From: Neville, Julie <Julie.Neville@lancashire.gov.uk>
Sent: 26 February 2025 13:40
To: Planning
Cc: Paulson, Ros
Subject: 3 2025 0027 Colliers Farm Whalley Old Road Billington BB7 9LF
Attachments: 3 2025 0027 Overlay.pdf

Reference 3/2025/0027
Location Colliers Farm Whalley Old Road Billington BB7 9LF
Proposal Proposed construction of a steel portal-framed agricultural building for livestock.

LOCATION
Scale 1:1250

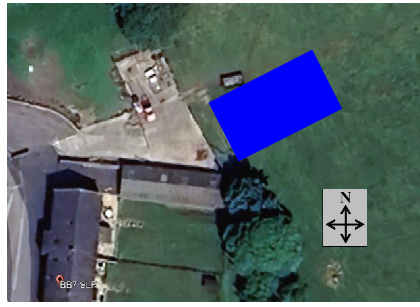
The proposed agricultural building will obstruct footpath FP0306029, as shown on the attached overlay, requiring a Public Path Order under the provisions of the Town and Country Planning Act 1990 Section 257 (TCPA90 S257). TCPA90 S257 orders are administered by the authority that is considering, or has granted the planning permission, in this instance Ribble Valley Borough Council.

The detail of the exact alignment of the new route, the construction specification and any association works would need to be agreed with the Public Rights of Way Team before the necessary TCPA90 S257 Order is made. I can advise that the new route must have a minimum width of 2 metres, have a firm constructed surface with no gates or stiles crossing the new route. If required for stock control the limitation of a self-closing pedestrian or kissing gate to BS 5709:2018 standards would be permitted.
